MetroWest, Portishead to Bristol, Passenger Rail Link Phase I DCO: Consolidated Submission to the Planning Inspectorate following the ExA Open Floor Hearing of 19th October 2020

Item 1 Public Participation: Supplementary Submission with Corrections on Question(s) to the Council following the Easton in Gordano Parish Council Meeting of Tuesday, 20th October 2020

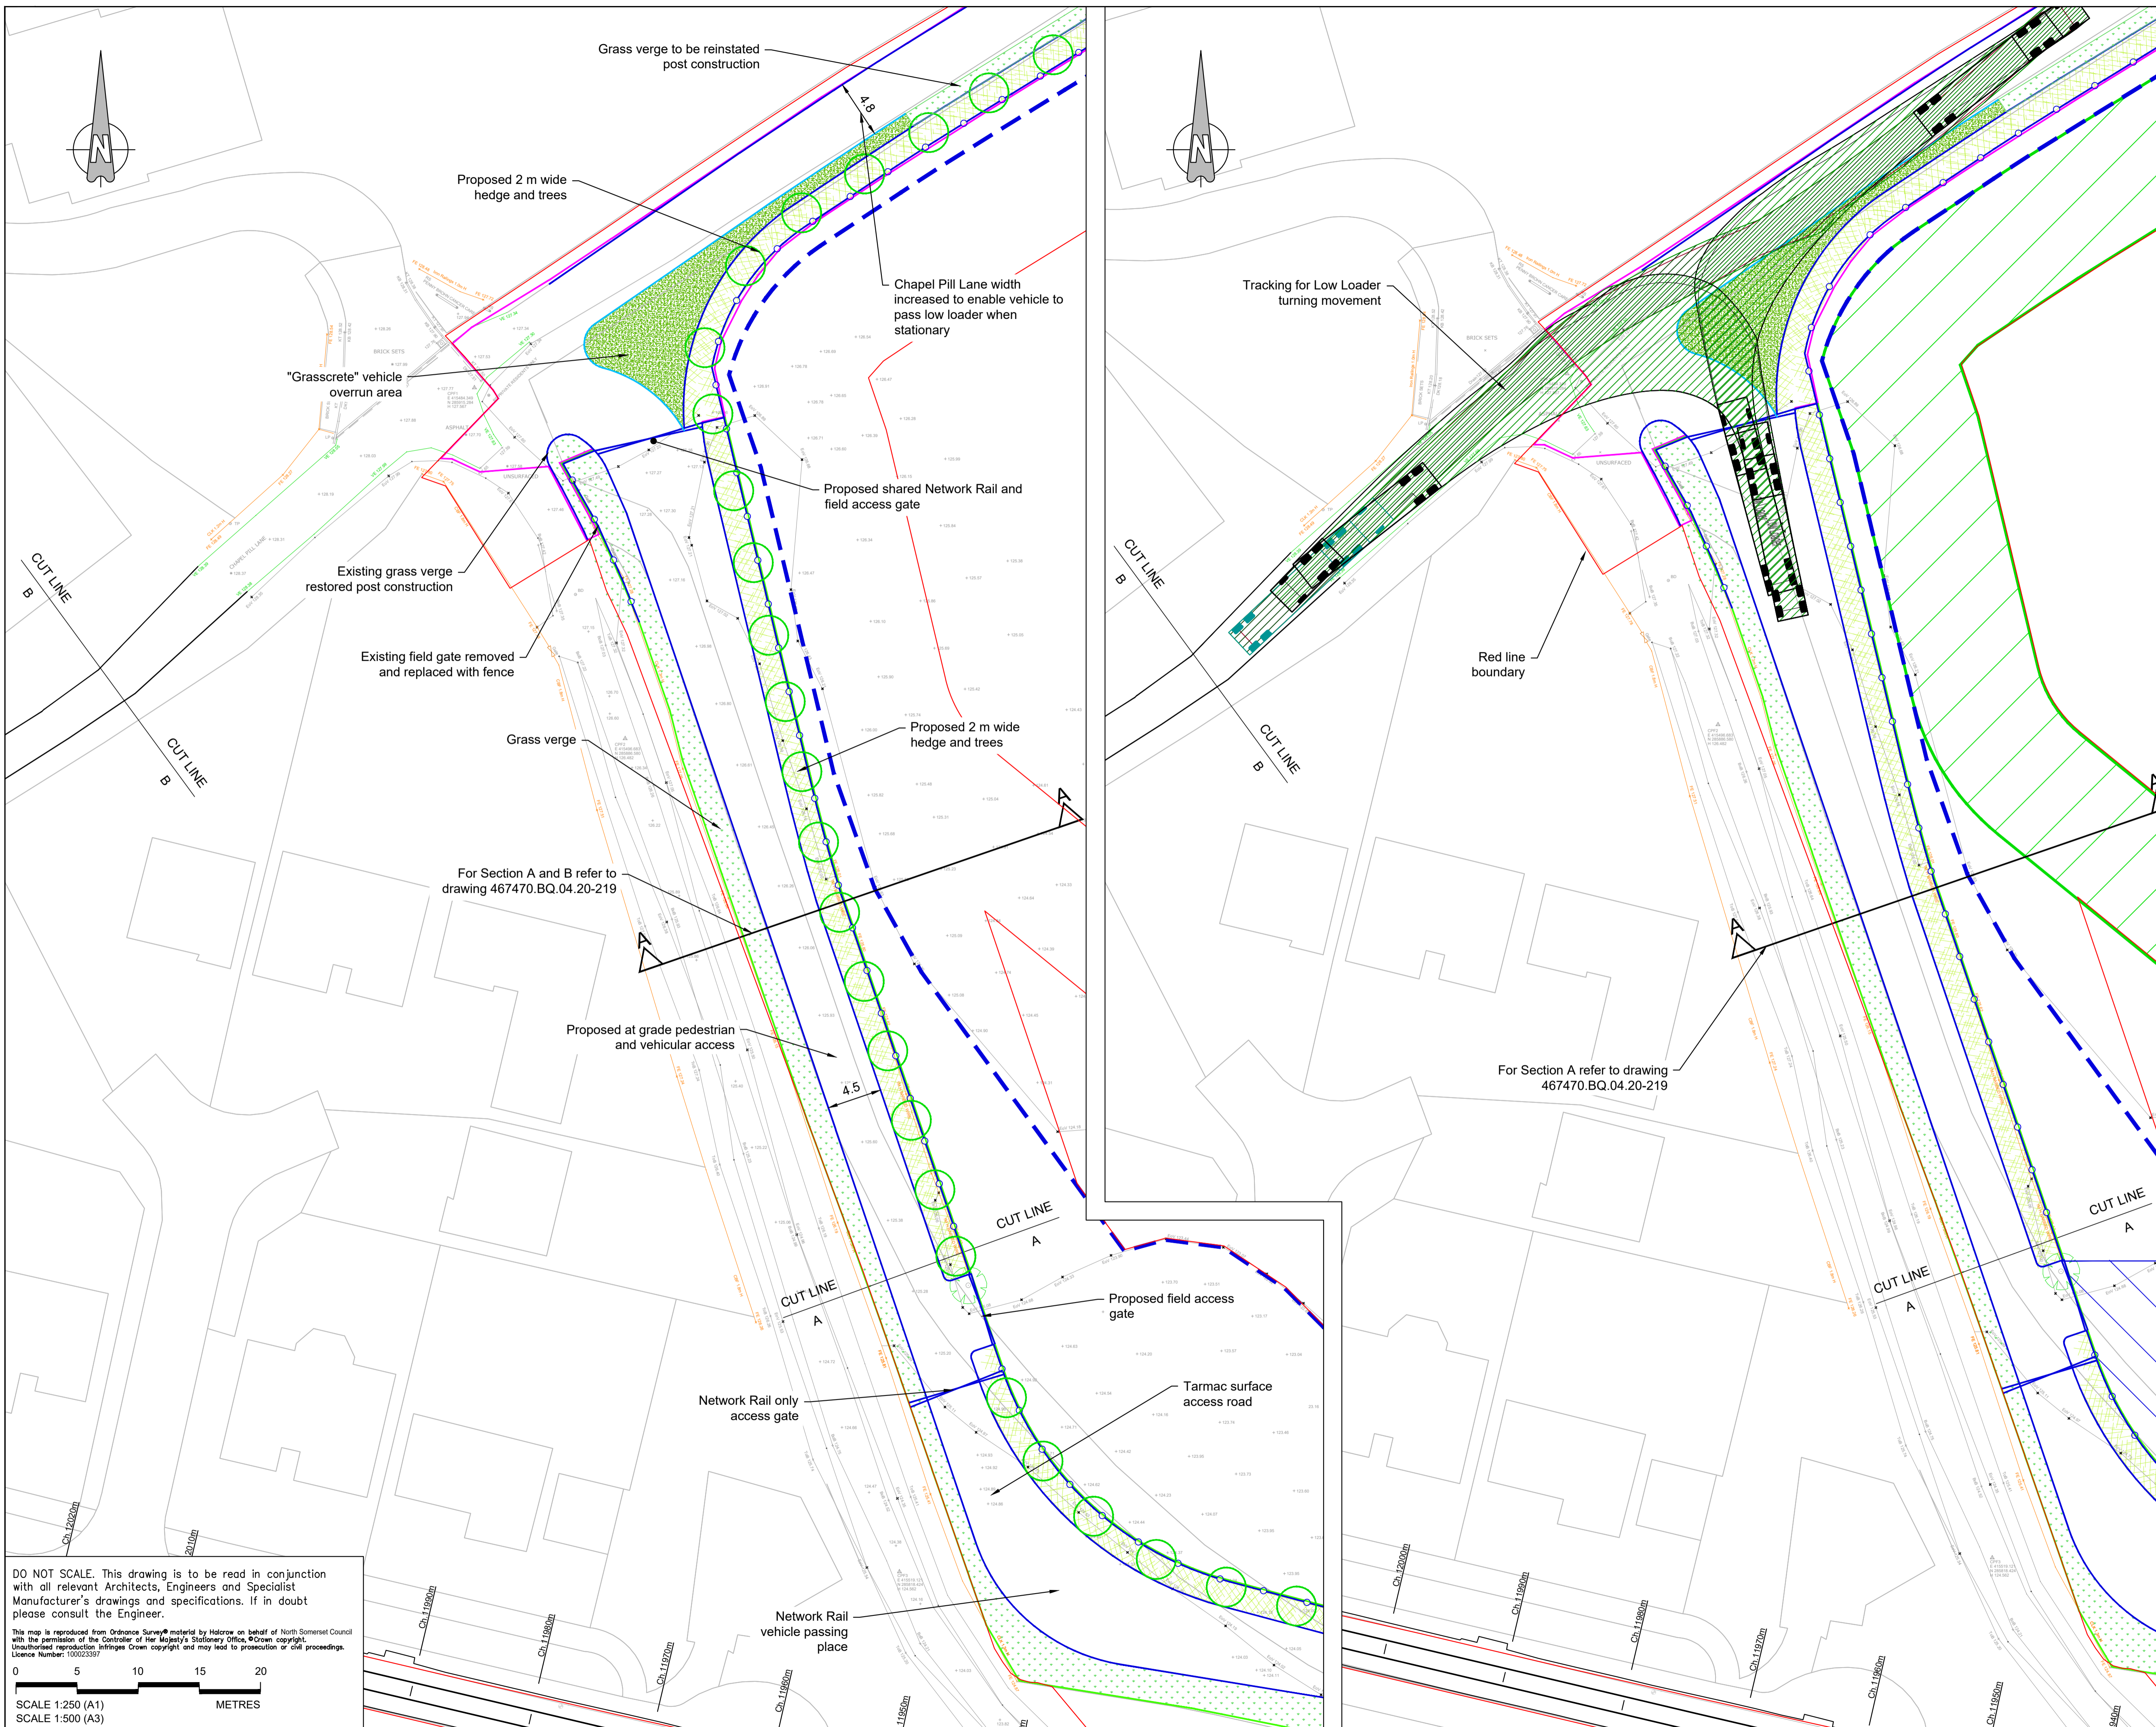
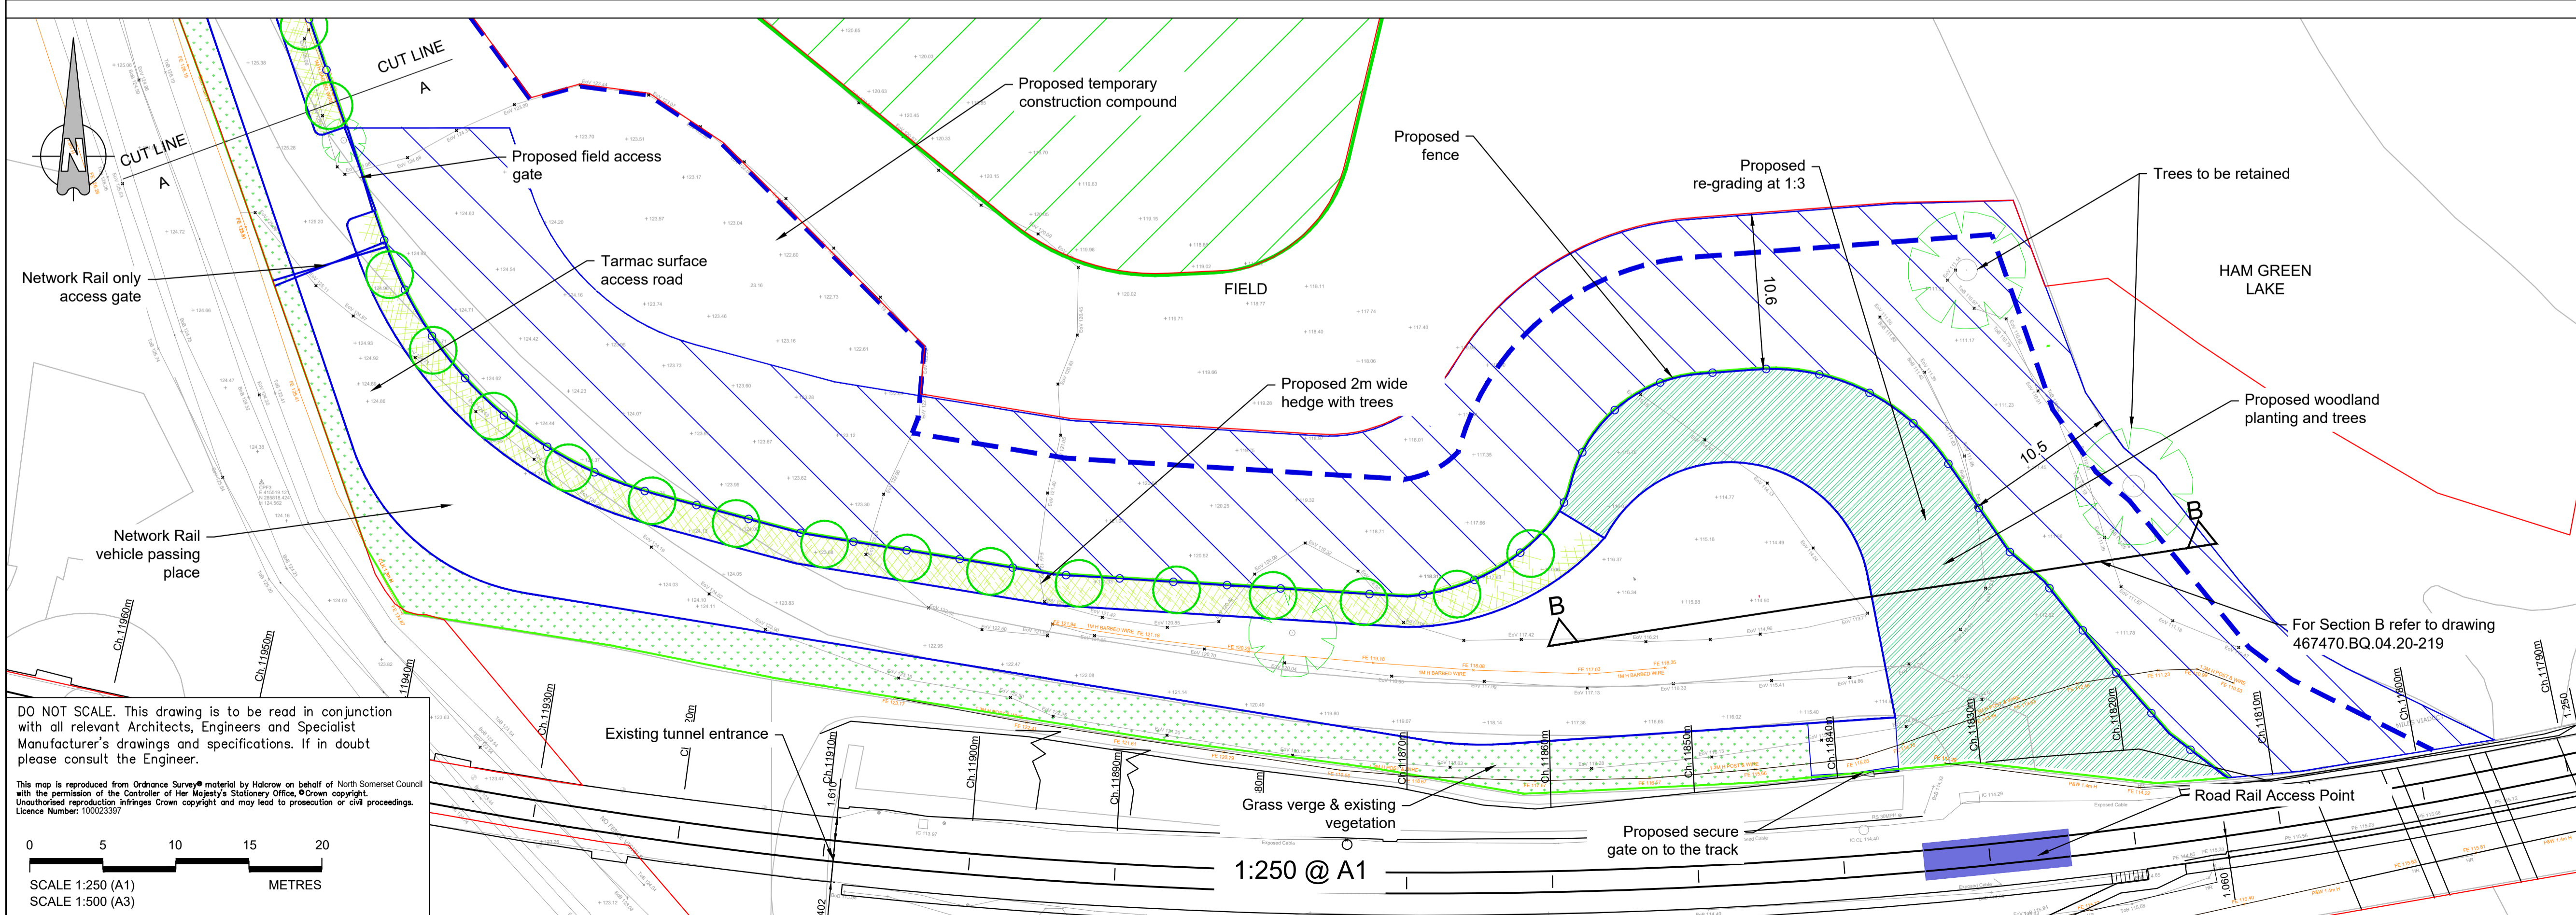
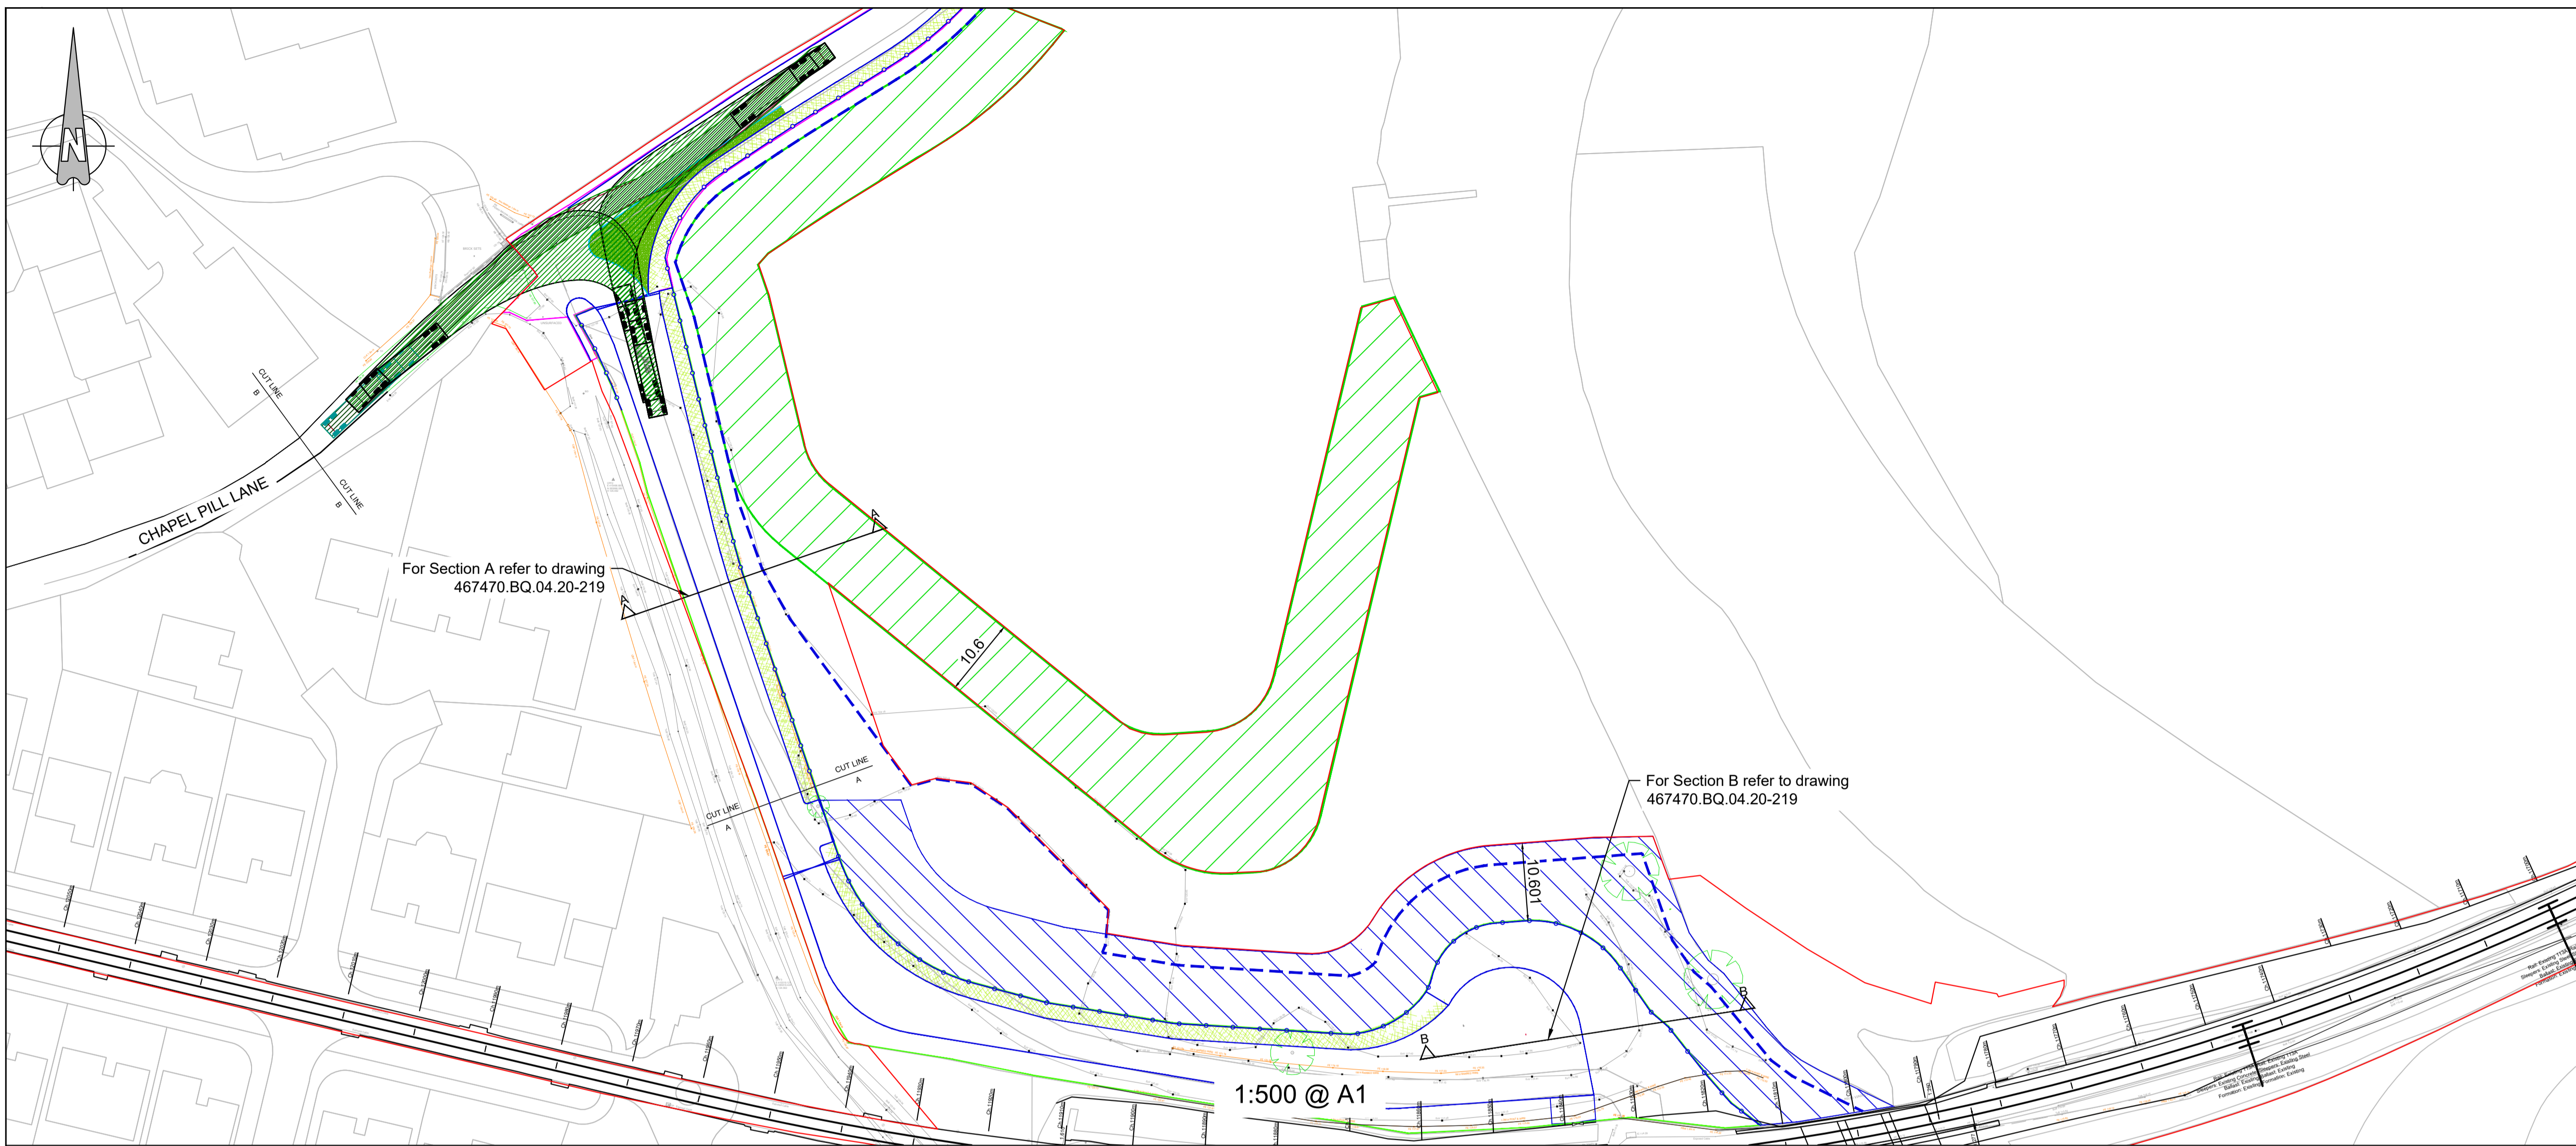
Can we be clear about what is proposed for the Pill Tunnel access and construction materials compound: is it a temporary compound during construction works or will it be a permanent compound with maintenance materials – ballast, sleepers, etc - stored there until needed?

Secondly, related to this, with regard to HGV low loader traffic impacts on very narrow access roads and lanes, and environmental and biodiversity impacts on the Ham Green Lake SNCI [corrected from SSSI in the oral submission at the hearing], could these construction materials be stored elsewhere, e.g. at another large rail compound or perhaps a compound to be constructed at Royal Portbury or Avonmouth Docks, to be brought by rail to the Pill Tunnel as and when needed, i.e. using the stock control protocol of “Just in Time”?

Thirdly [introduced as an additional question following the Open Floor Hearing on 19th October] can reassurance be provided that the Hayes Mayes Lane access to the Pill Tunnel Rail Compound will not be used, nor have landowner negotiations been entered into, to facilitate the proposed development of up to 16 affordable housing units as referenced in the Abbots Leigh, Ham Green, Pill and Easton-in-Gordano Neighbourhood Plan which, despite considerable resistance from local residents supported in their objections by Dr Liam Fox MP, has been approved for submission to North Somerset Council by both Abbots Leigh and Easton-in-Gordano parish councils (paragraph 5.6, page 17, of the Plan, plus a written submission on behalf of local residents to the 20th October 2020 meeting of Easton-in-Gordano Parish Council, are attached). In addition, to the extent that it bears directly on this question that no agreement should be entered into now that contradicts a planning inspector’s previous refusal to allow a track and car park at this site for non-rail-related use, reproduced below is an extract of an email received from a local resident on 22nd October 2020, viz:
